Subject: A38 Derby Junctions - Summary of Discussions from the Hearing held on 11th December 2019.

Queries raised in relation to Item 12 for Euro Garages Ltd (EG)

Figure 5.2: Proposed Markeaton junction

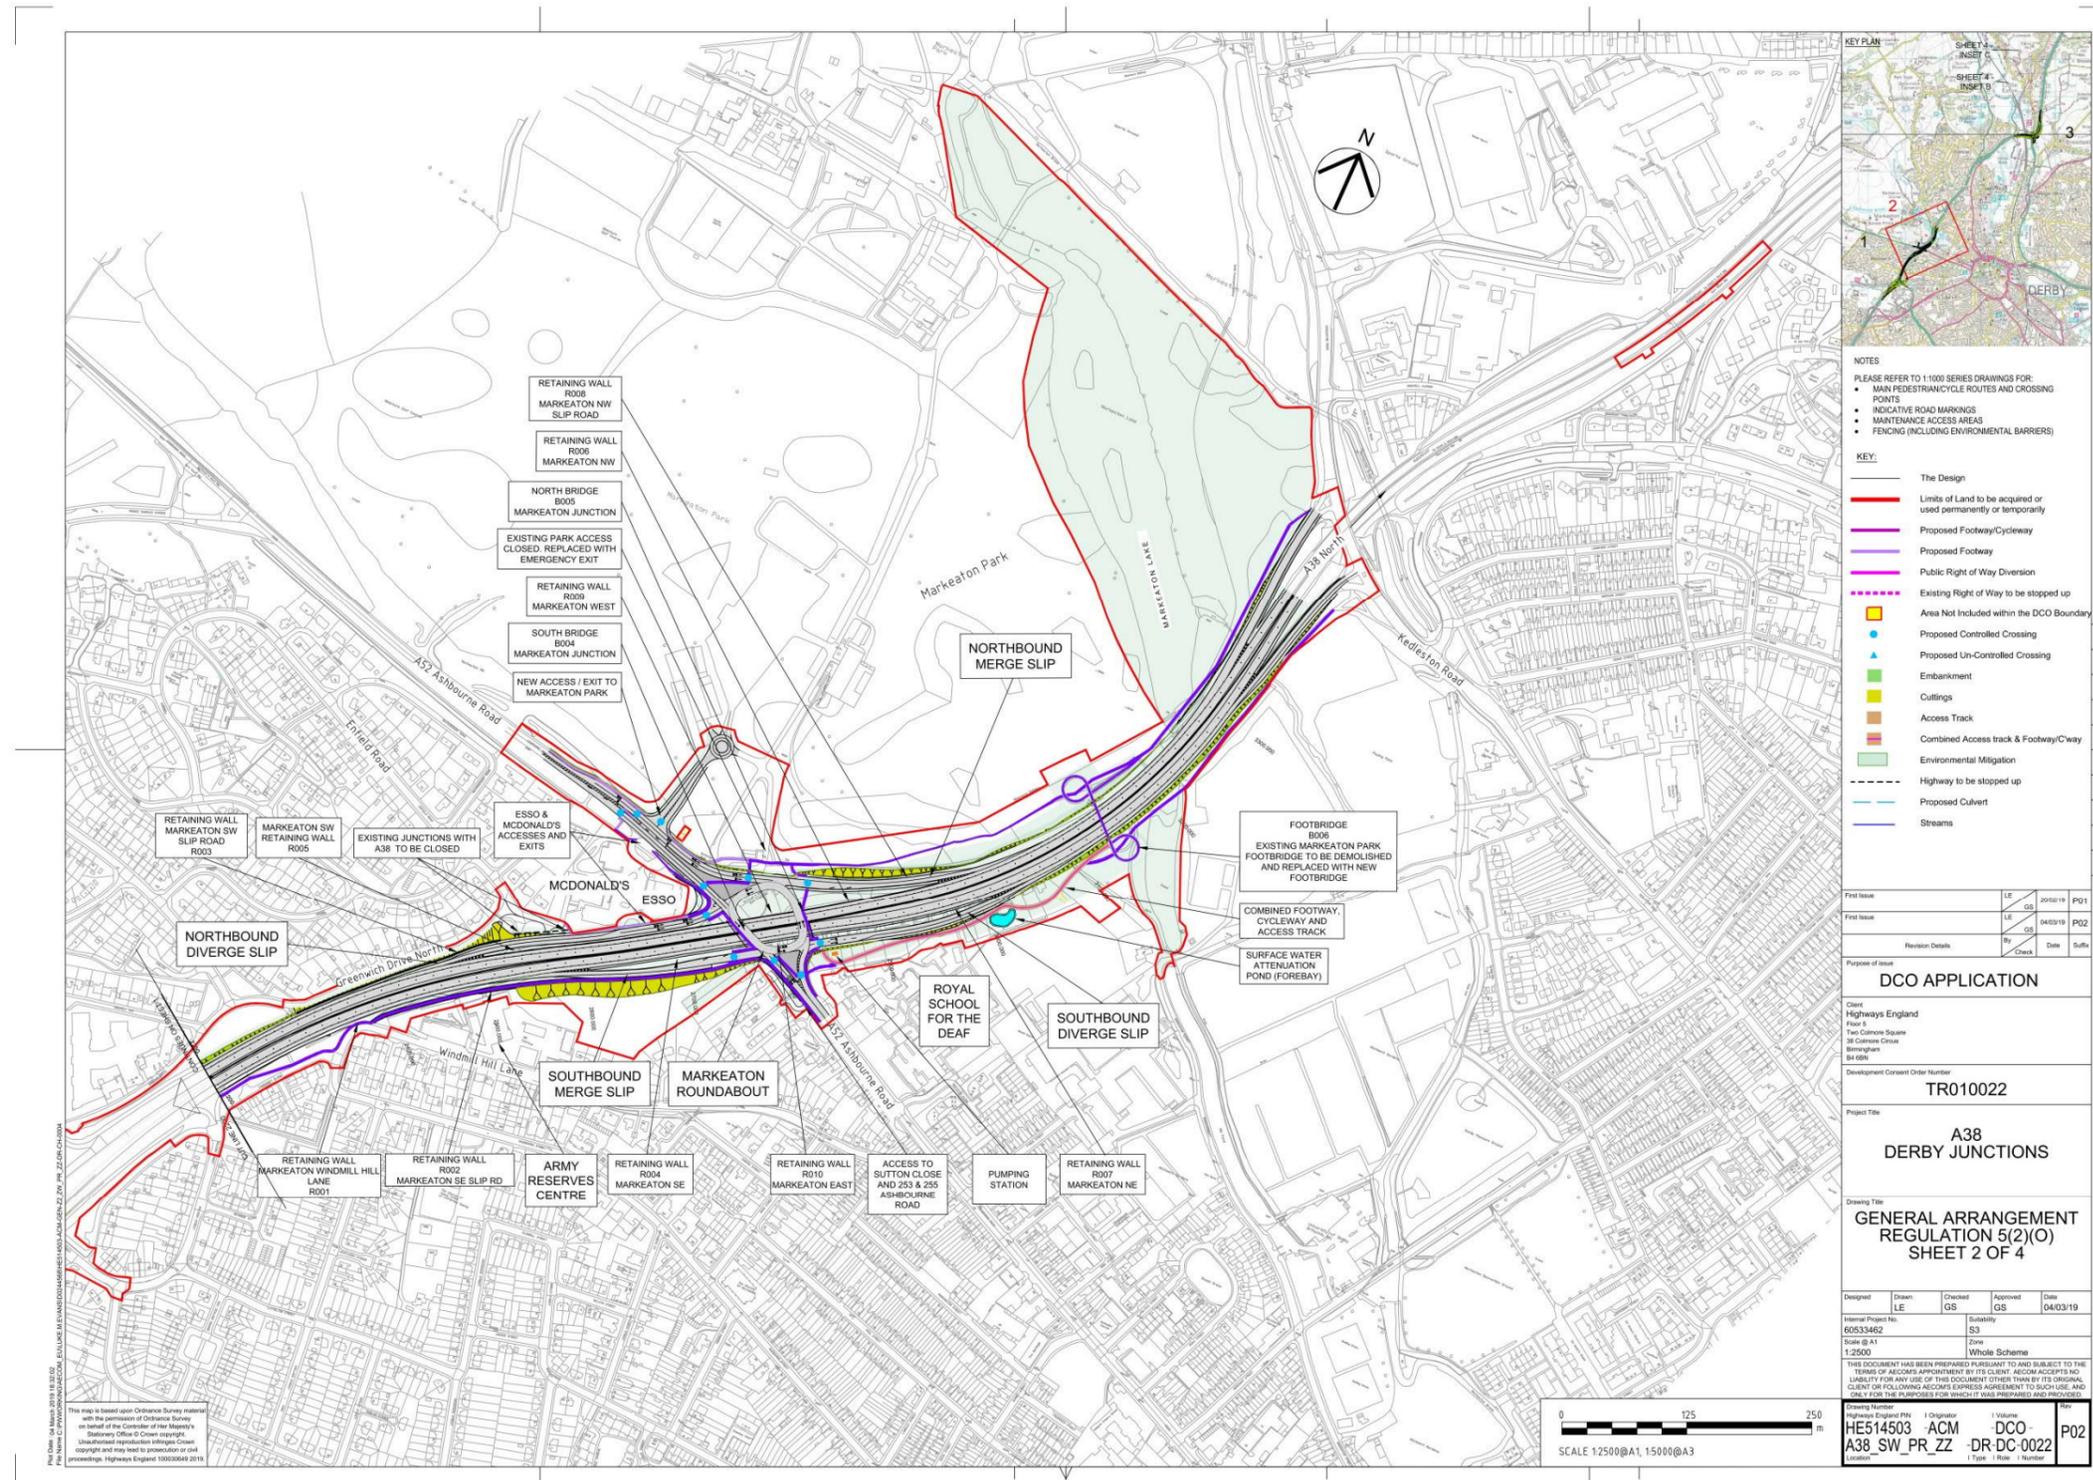
- d) The extremely sub standard geometry of the proposed A52 junction is of serious concern to EG because of the need for tankers and other HGVs to effectively and safely manage a U turn to enter their site. The safety of the A52 is challenged in technical terms as well as the potential for additional surface maintenance work due to the very tight turn into the site from the A52 junctions. EG requested sight of the Road Safety Audit for this junction prior to the Hearing. It was confirmed at the Hearing that the information would be made available and the information is awaited from Aecom.

- e) This is not a point for EG to comment upon other than to say if an ingress from the A38 could be achieved then the need for additional strengthening to the McDonalds car park would no longer be necessary.

- g) The lack of an entry from the A38 needs to be better explored with Aecom in the promised meeting. The adverse impact of the loss of the ingress has been explained and the loss of a simple access from the A38 is considered to be highly detrimental as the replacement access arrangements involve a far longer detour and involve passes through a number of stop lines and are therefore considered to be a deterrent to accessing the site from the A38 in commercial terms.
